**SUBMISSION FROM INNER WEST COUNCIL
TO THE DEPARTMENT OF PLANNING, INDUSTRY & ENVIRONMENT
OPPOSING THE PROPOSED WESTCONNEX STAGE 3 (M4-M5 LINK – ROZELLE
INTERCHANGE) - SSI-7485-MOD-2**

SEPTEMBER 2019

Figure 3-1 Proposed construction ancillary facility (C6a)

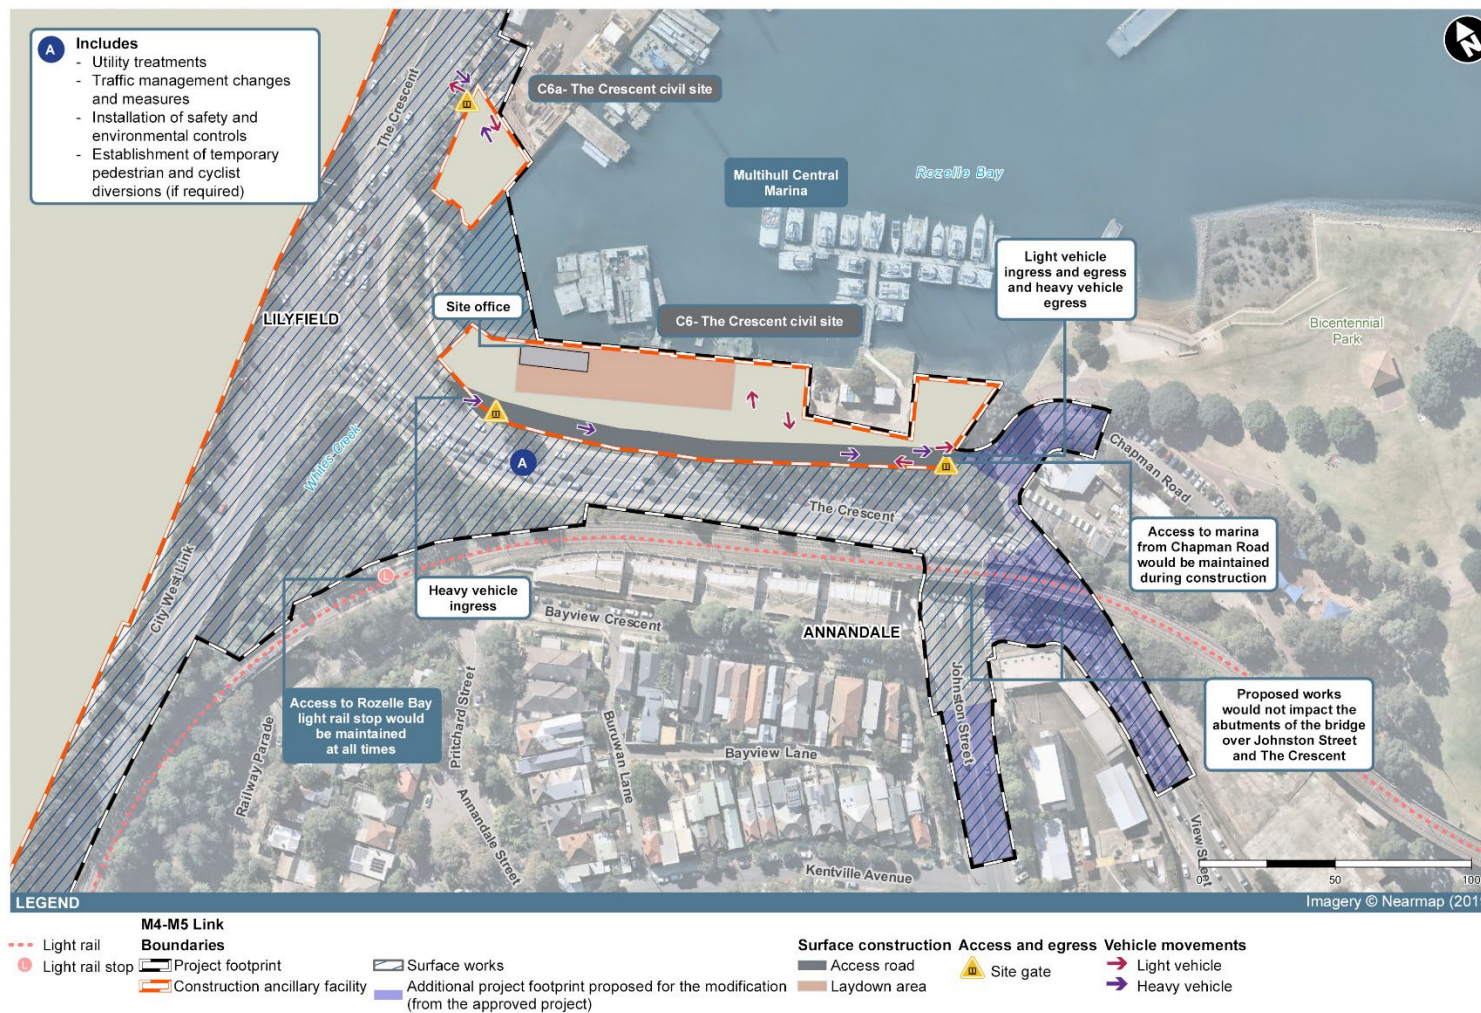
18. In relation to the additional construction ancillary facility on The Crescent (facility C6a), staff must be stationed on the footpath when any vehicle is entering/departing the facility.

This path is used by people walking and cycling, and people cycling westbound (downhill) are travelling fast. Drivers, especially truck drivers who are seated higher, tend to look 20-30m into the distance for approaching vehicles and can fail to see people walking or cycling immediately in front of the truck cabin.

Figure 4-1 Rozelle Interchange: 'with project' road network

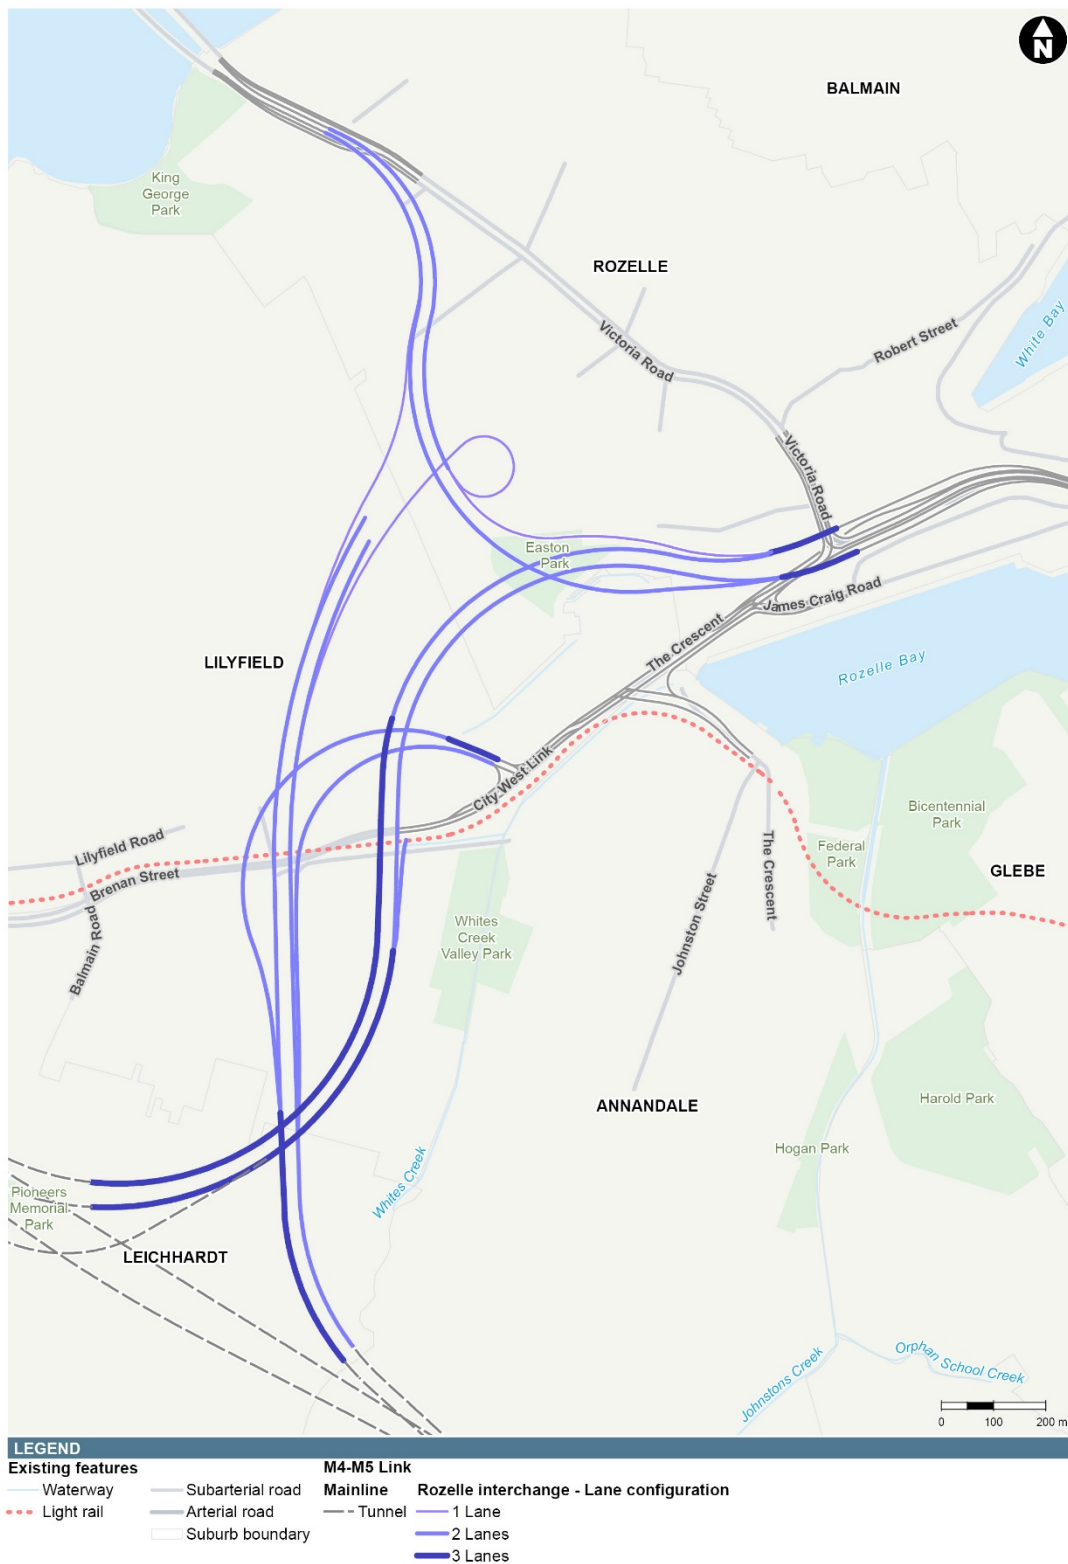
11. Bicycle parking with weather protection be provided on the land bridge adjacent to the Rozelle Bay light rail stop.
12. As reflected in Figure 4-1 (page 4-3) of the modification, a path be provided to allow people to walk and cycle between The Crescent and Railway Parade (similar to the connection now provided by the path through Buruwan Park).

Figure 4-2 The Crescent/Johnston Street/Chapman Road layout in EIS and proposed modification model

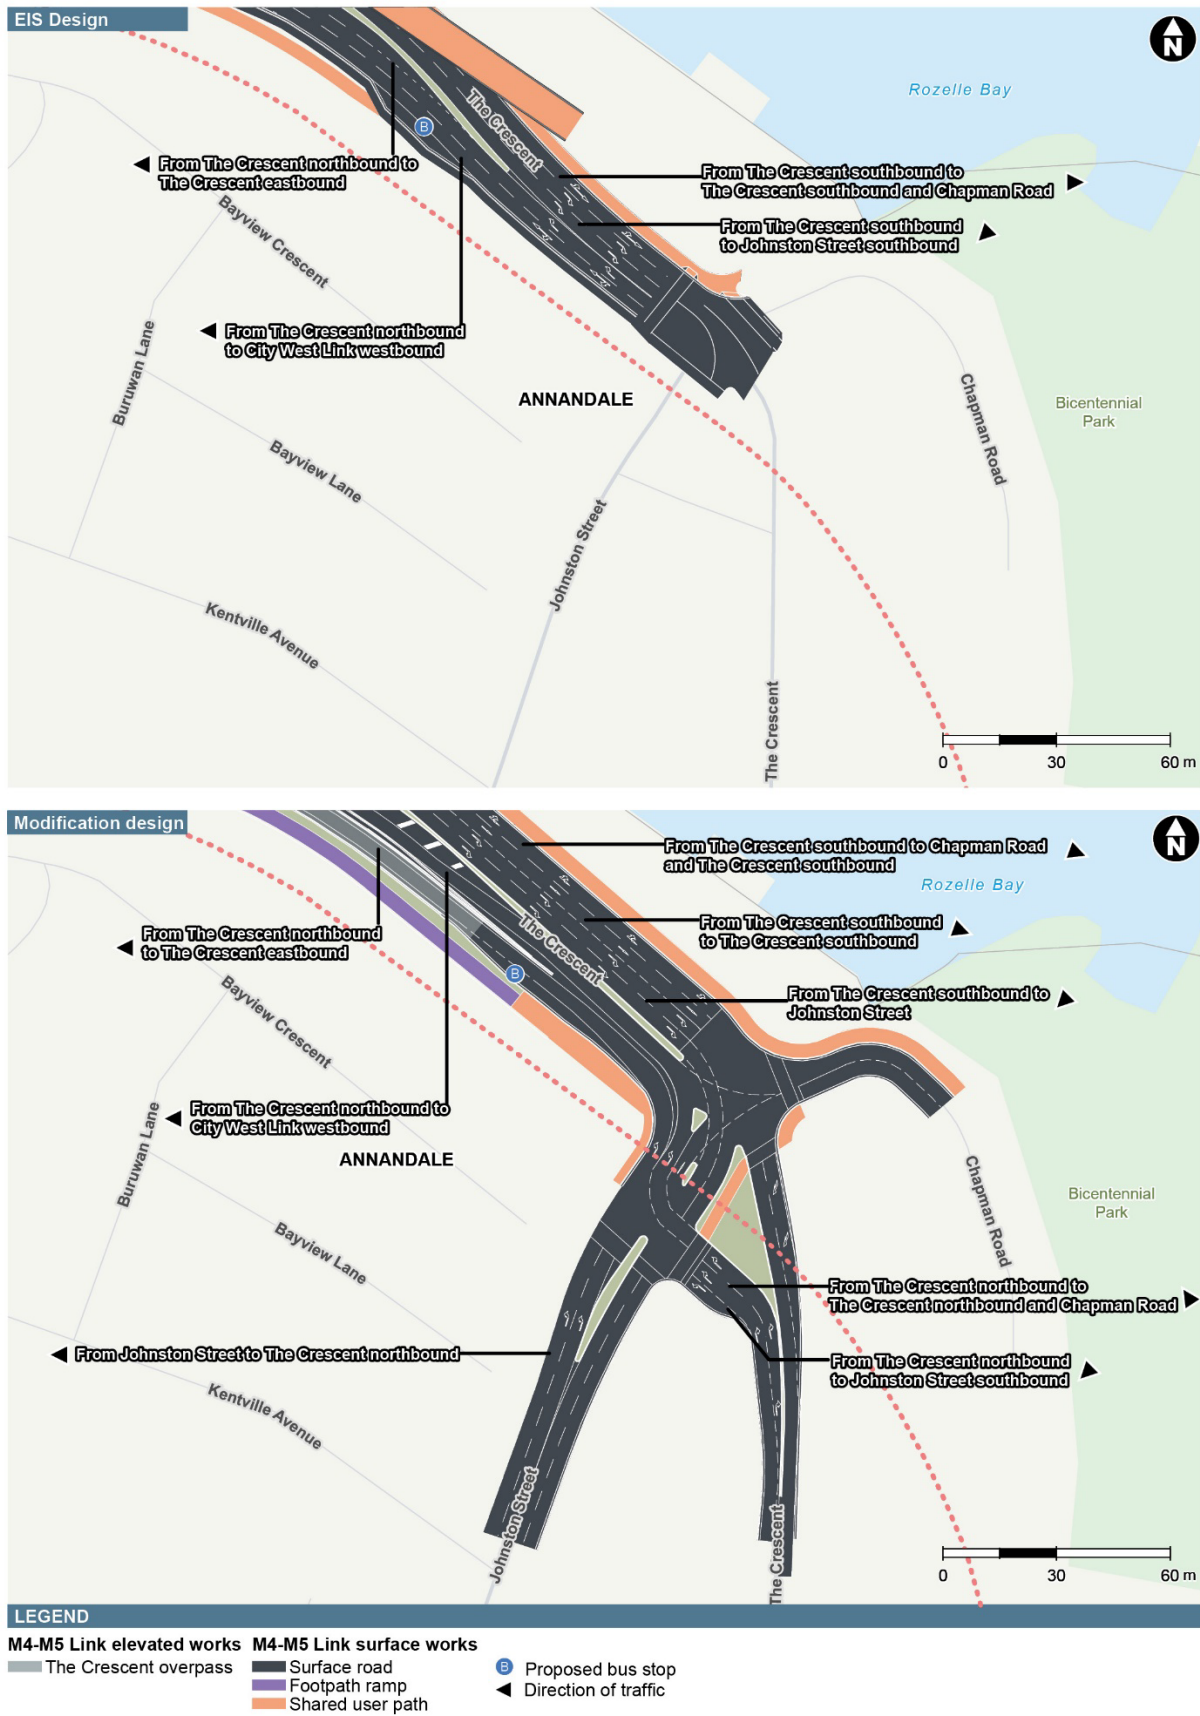
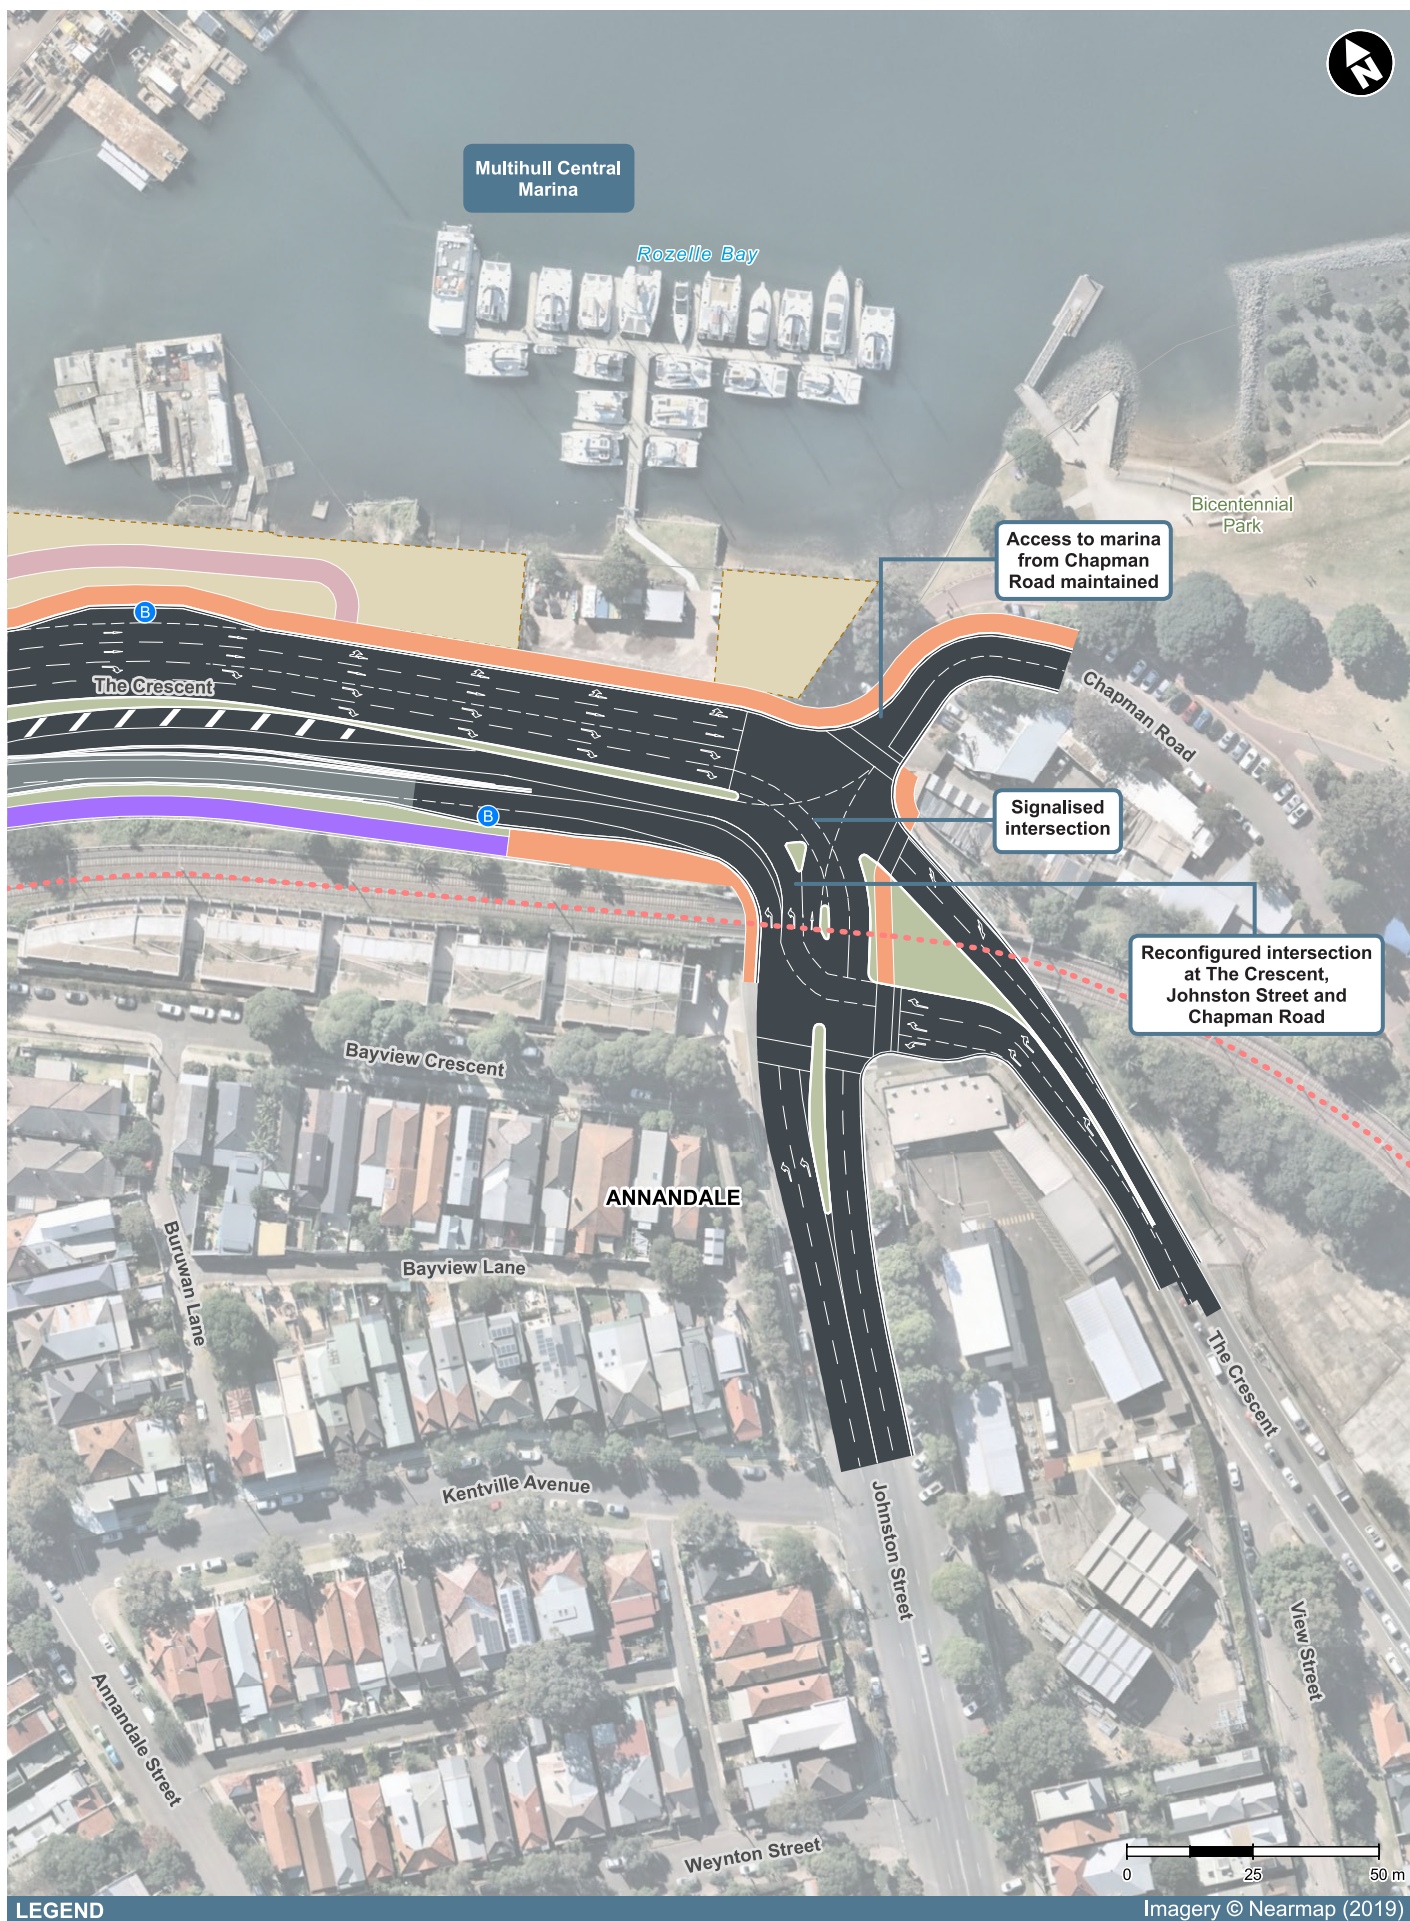
A significant active transport issue raised by the modification is the addition of extra road crossings at The Crescent. Currently people can walk directly between North Annandale and open space at Rozelle Bay via a single crossing. By adding a further crossing points each with separate signal cycles, the modification will significantly increase the time and distance taken to cross The Crescent, imposing a significant barrier

- Real and perceived personal safety on the shared user bridge;
- Circuitous access to cross The Crescent to reach the foreshore resulting from the removal of direct active transport links and creation of a convoluted route requiring the use of four crossing points;
- Lack of direct, grade separated access from Annandale North to the Foreshore (as proposed in the EIS);
- Removal of direct active links to facilities on the foreshore including the new skate park and playground, isolating the community, the foreshore and, ultimately, the proposed Bays Precinct revitalization.

3. Traffic signals proposed at the intersection of Johnston Street, The Crescent and Chapman Road at North Annandale be programmed to favour walk/cycle demands over motor vehicles – to respond immediately when a pedestrian or cyclist seeks to cross (demand responsive activation).

Figure 4-7 Elevation: Indicative view of the shared user path bridge

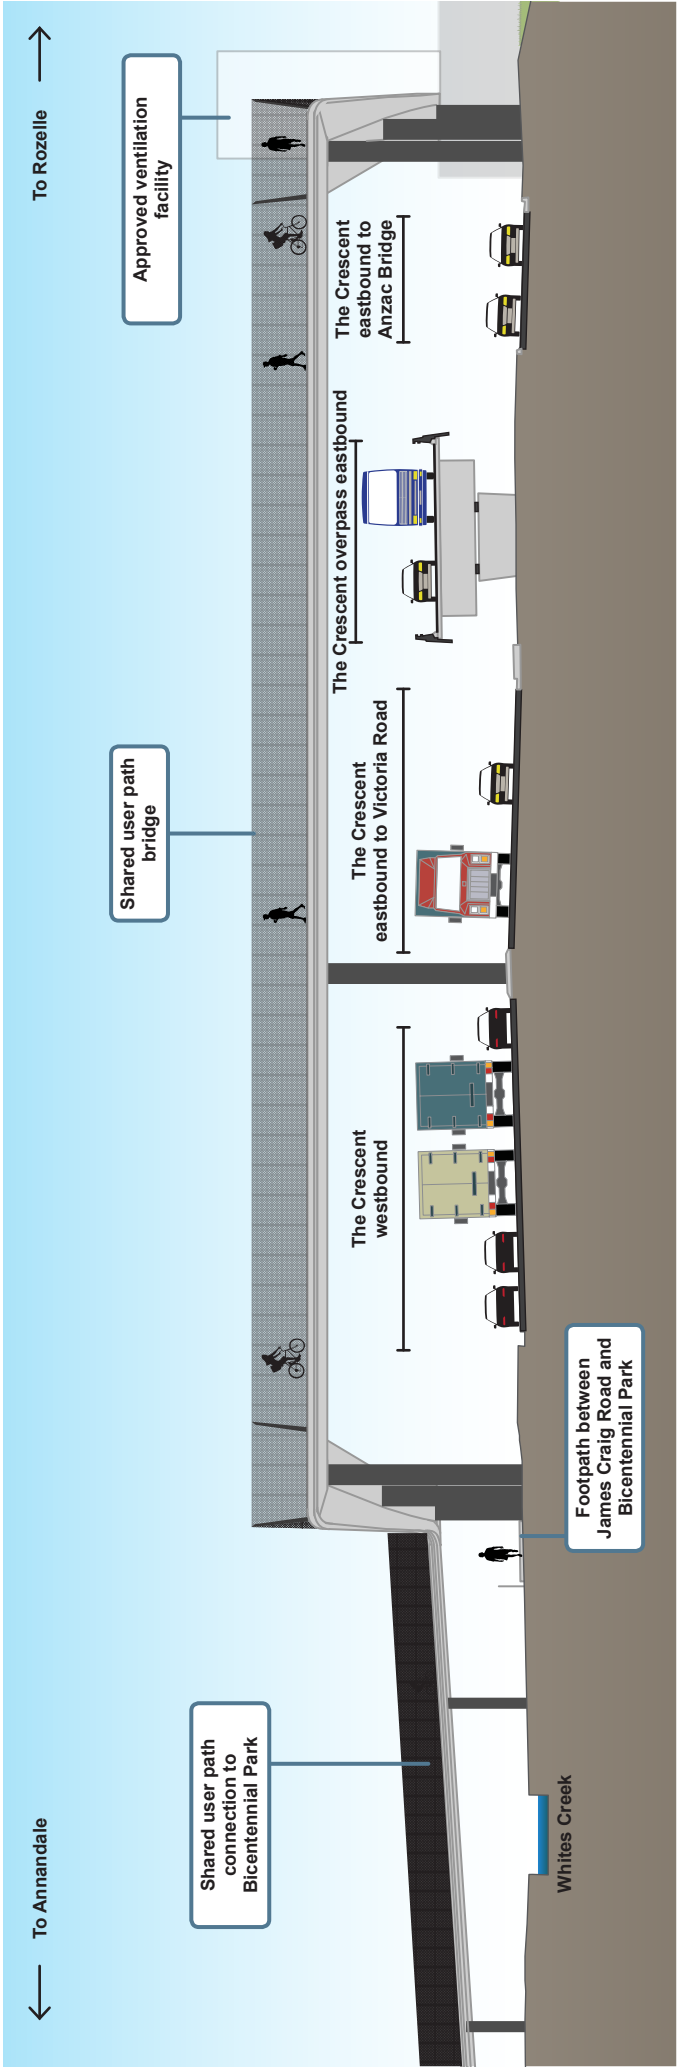
7. On the proposed shared user path, stairs be provided to minimise unnecessarily long and circuitous walking distances and provide an opportunity for people to exit the overbridge quickly and gain the attention of passing motorists if they feel unsafe.

Suggested stair locations are shown below and should account for future pedestrian movements resulting from revitalisation of the Bays Precinct. The connections should be legible and direct to provide faster walking access for people who can use them.
